Our ref: HA/2013/114344/01-L01
Your ref: A/74/13
Date: 28 June 2013

**PROPOSED DISTRIBUTION WAREHOUSE AND COVERED STORAGE, TRADE COUNTER AND ASSOCIATED OFFICES. UPGRADING OF ACCESS ROAD FOR AND IMPROVEMENT OF EXISTING JUNCTION WITH THE A27. THIS APPLICATION IS A DEPARTURE FROM THE DEVELOPMENT PLAN AND AFFECTS A PUBLIC RIGHT OF WAY.
THE VINERY POLING BN18 9PY**

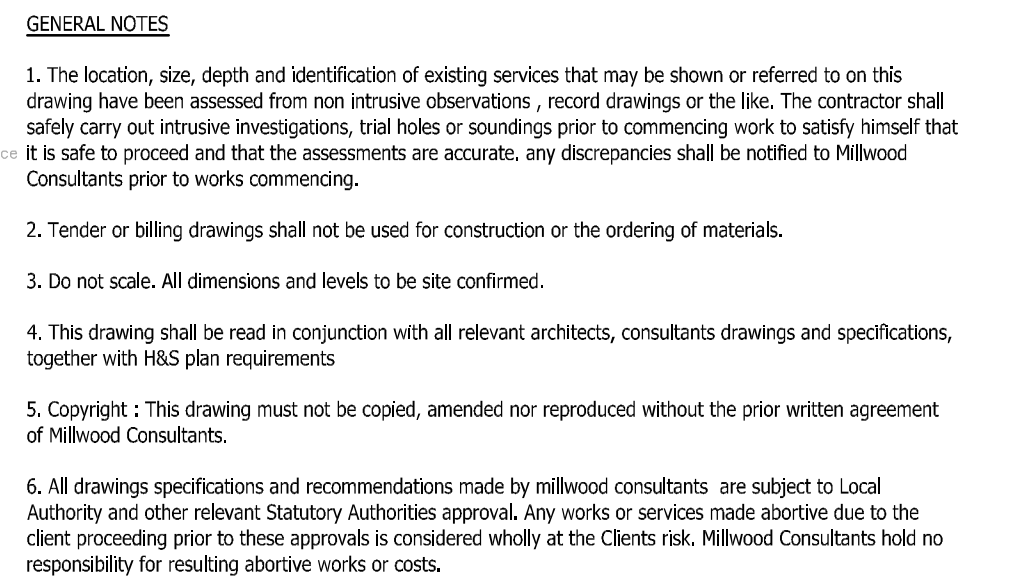
- Further details are required on the proposal to install a package treatment plant for treating foul drainage. If you wish to discharge treated sewage effluent into a surface water or to ground you may require an Environmental Permit from the Environment Agency. You should apply online at <http://www.environment-agency.gov.uk/business/topics/permitting> or contact 08708 506506 for an Environmental Permit.

The development hereby permitted shall not be commenced until such time as a scheme to dispose of foul drainage has been submitted to, and approved in writing by, the local planning authority. The scheme shall be implemented as approved.
